# **LATTA ENGINEERING, PLLC**

**Re: Technical Review #1 Comments – PA22-019  
Groundhog PRD, 5110 83 Avenue NE, Marysville, WA**

Latta Engineering Ltd (LE) has prepared this letter to summarize project design revisions in accordance with your City staff technical review comments letter dated June 28, 2022 (see attached copy for reference).

**GRADING AND COMPOSITE UTILITY PLAN**  
GROUNDHOG PLANNED RESIDENTIAL DEVELOPMENT

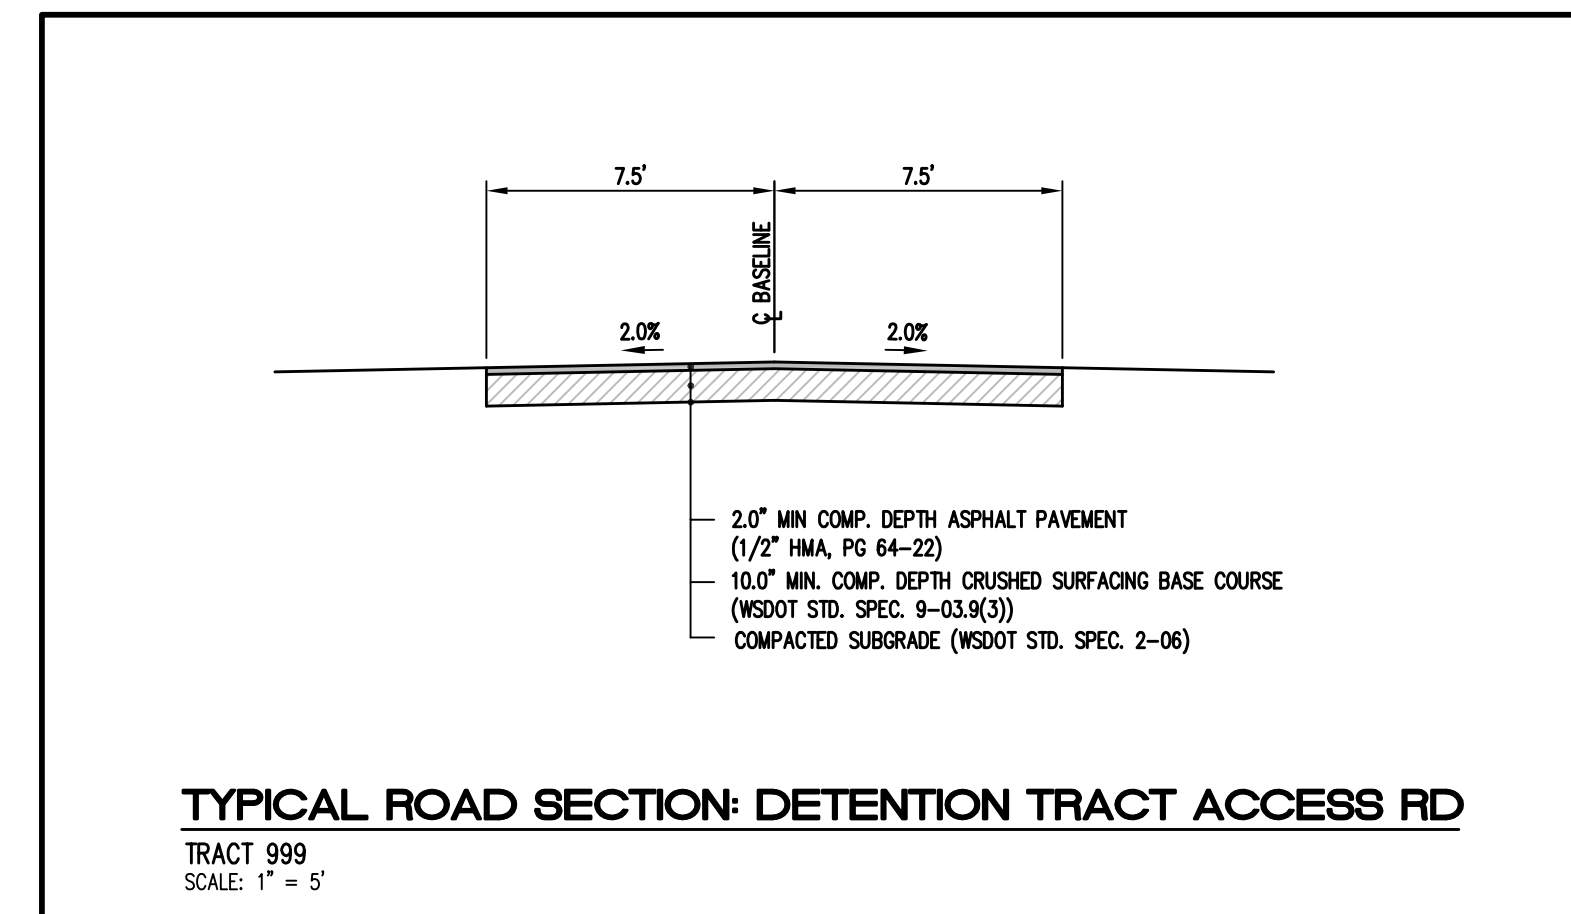
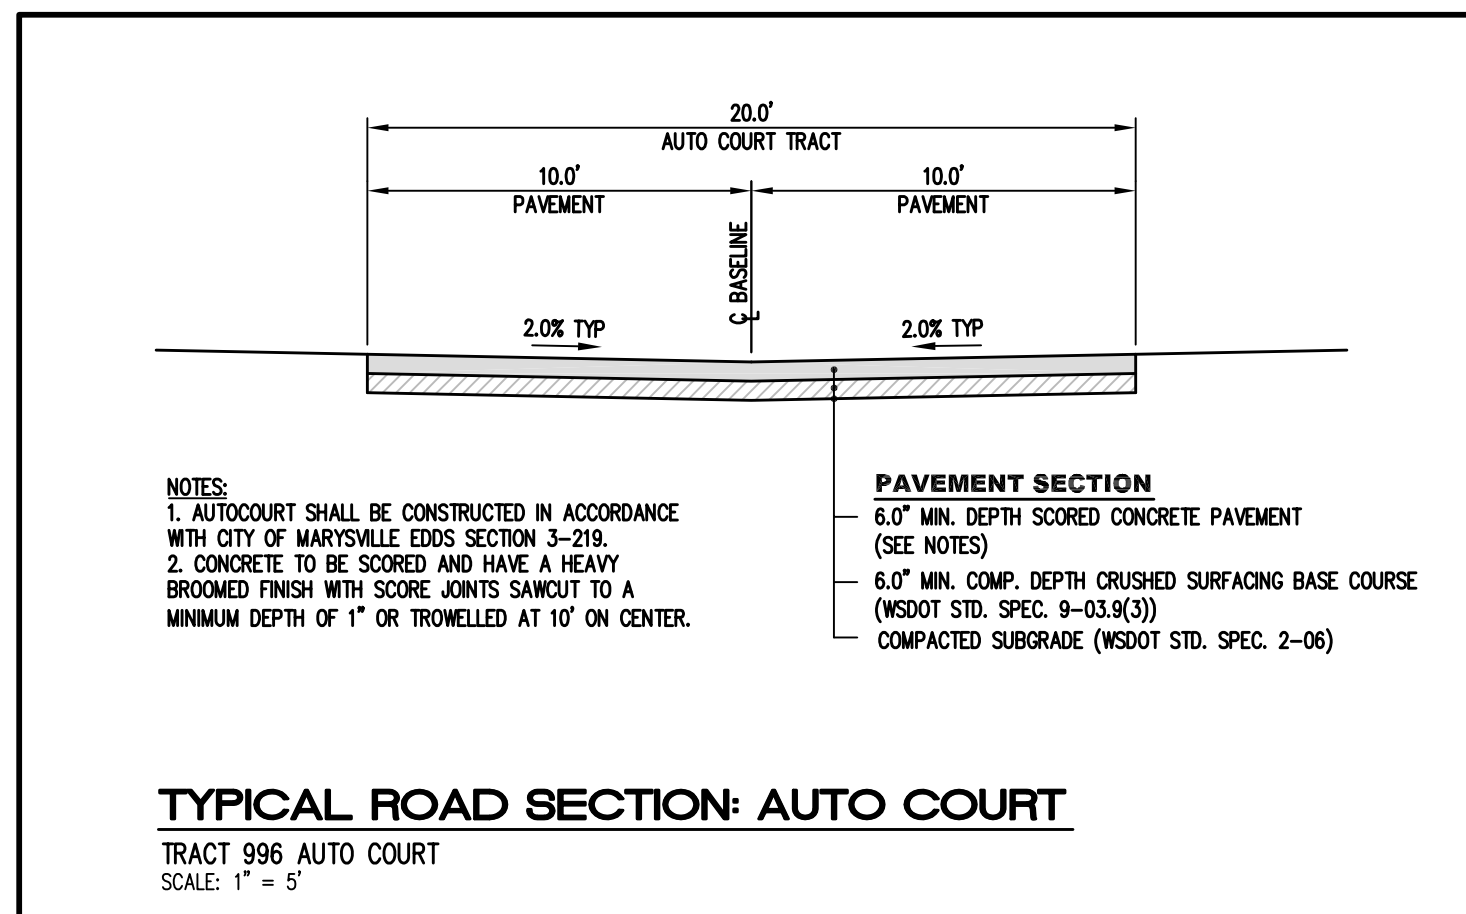
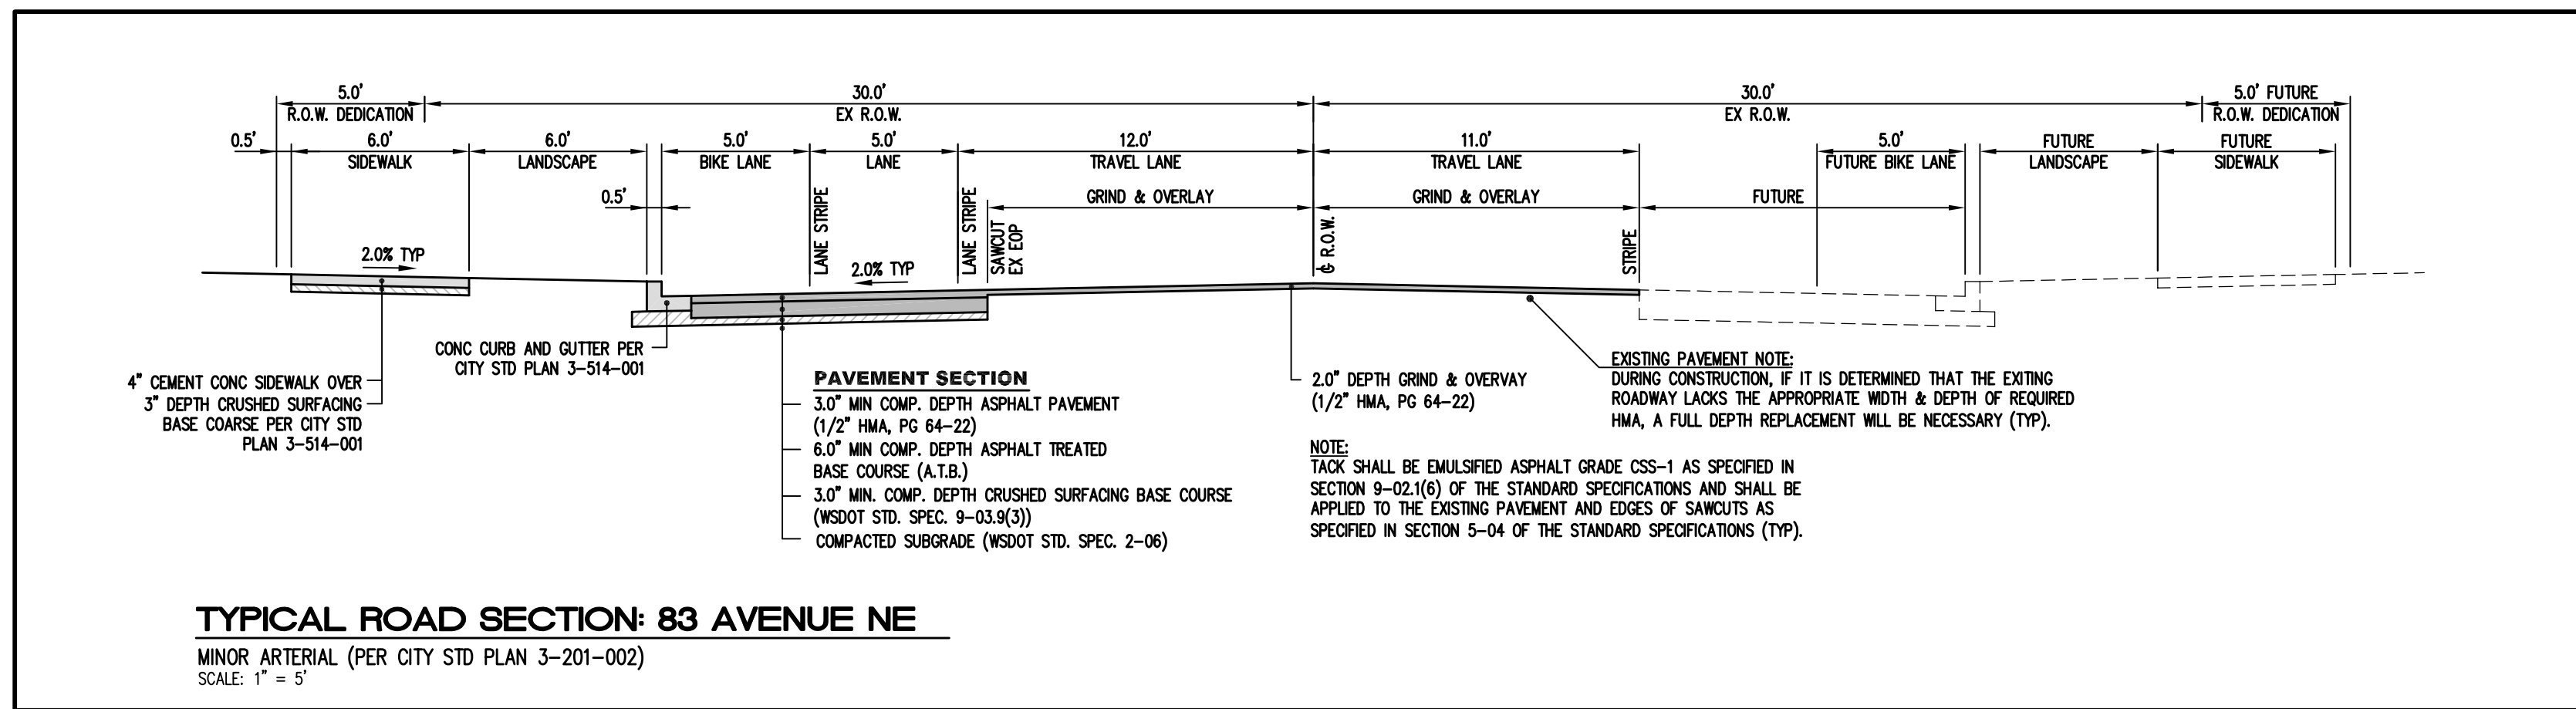
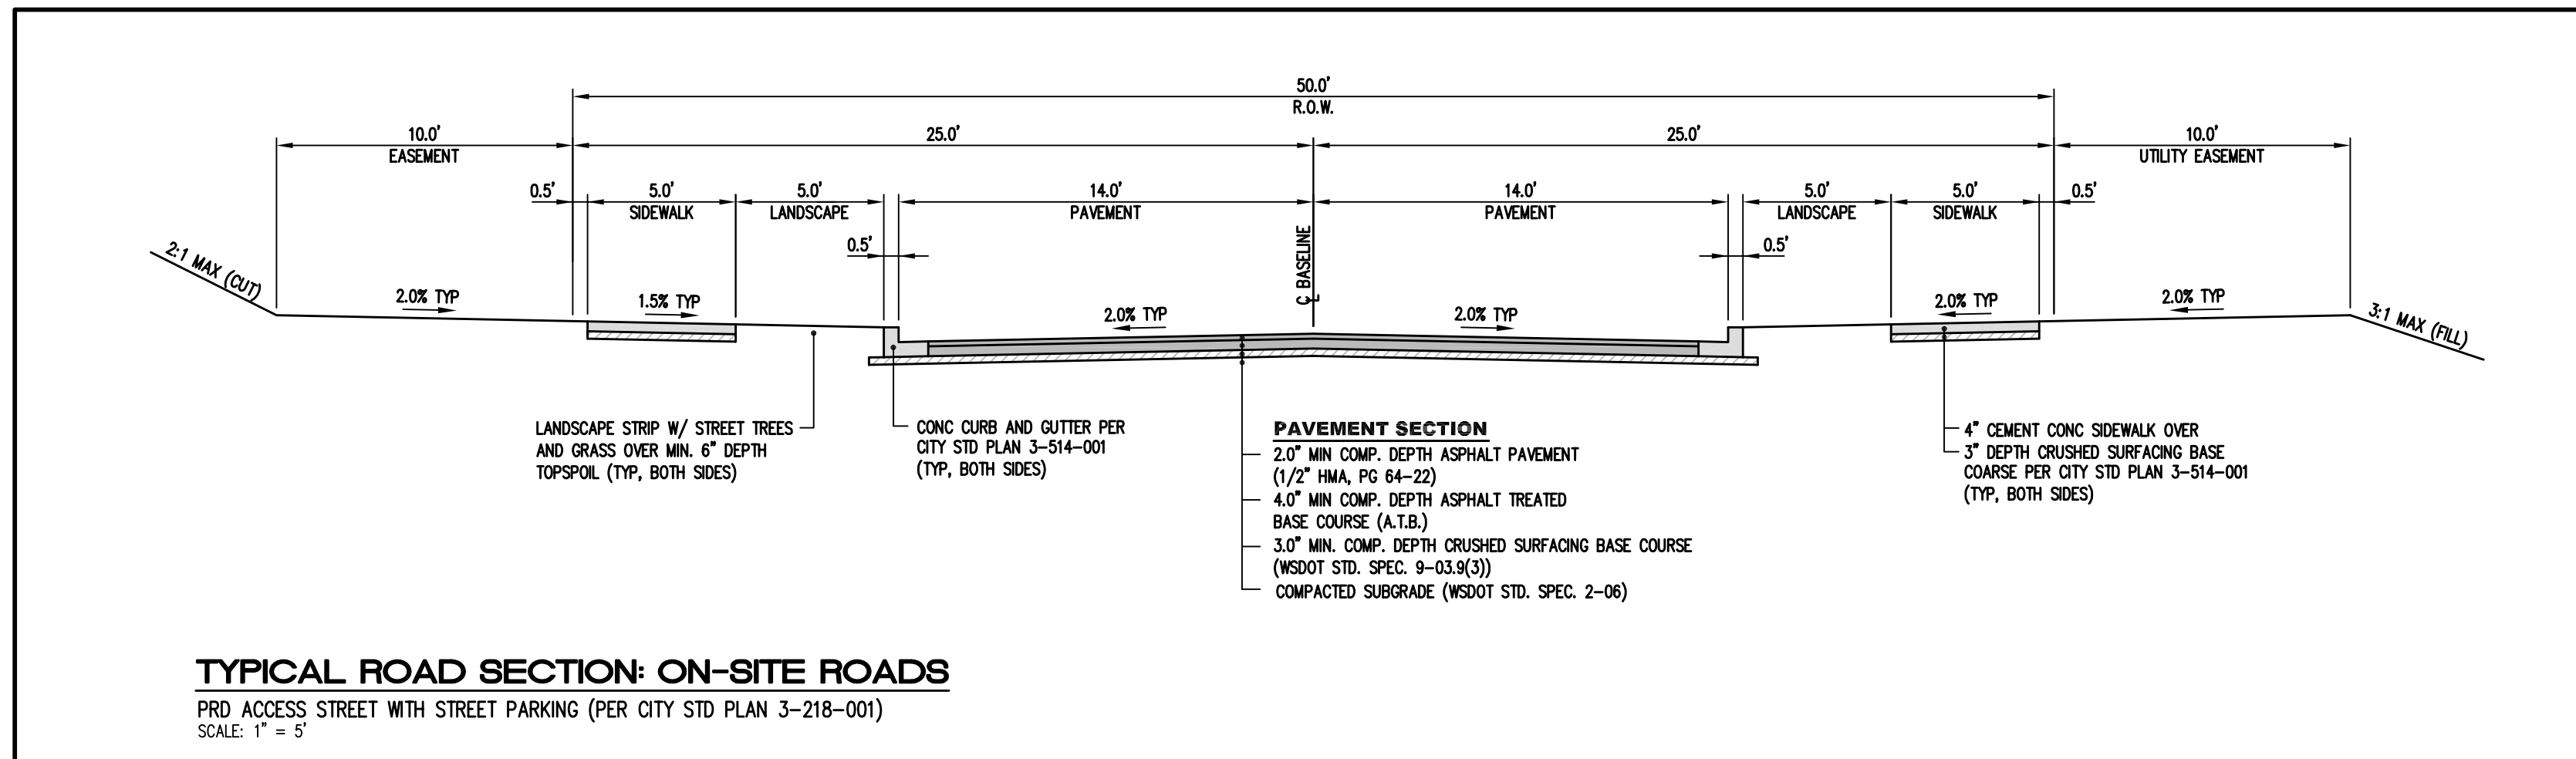
2. Based on review of Sheet C-4, there appear to be multiple retaining walls proposed with development. Please clarify how compliance with MMC 22D.050.030(4) is to be satisfied if the proposed retaining walls exceed 4 ft. in height:

- As shown on the revised preliminary *Grading and Composite Utility Plan (Sheet C-4)*, retaining walls proposed within the development will typically be less than 4 ft in height (see revised plan that includes top and bottom of wall elevations as requested).

- Lot 8 may be the exception (wall height is currently shown at 5 ft height). This wall is proposed to be terraced per City code requirement (terraced section will be separated by a 2 ft landscape bed).

- Please note that the final construction drawings (final civil design) will be designed to ensure balanced cut & fill earthwork for the project and will most likely propose all retaining walls to be less than 4 ft in height. Moreover, if walls greater than 4 ft are absolutely required, they will be terraced as noted.
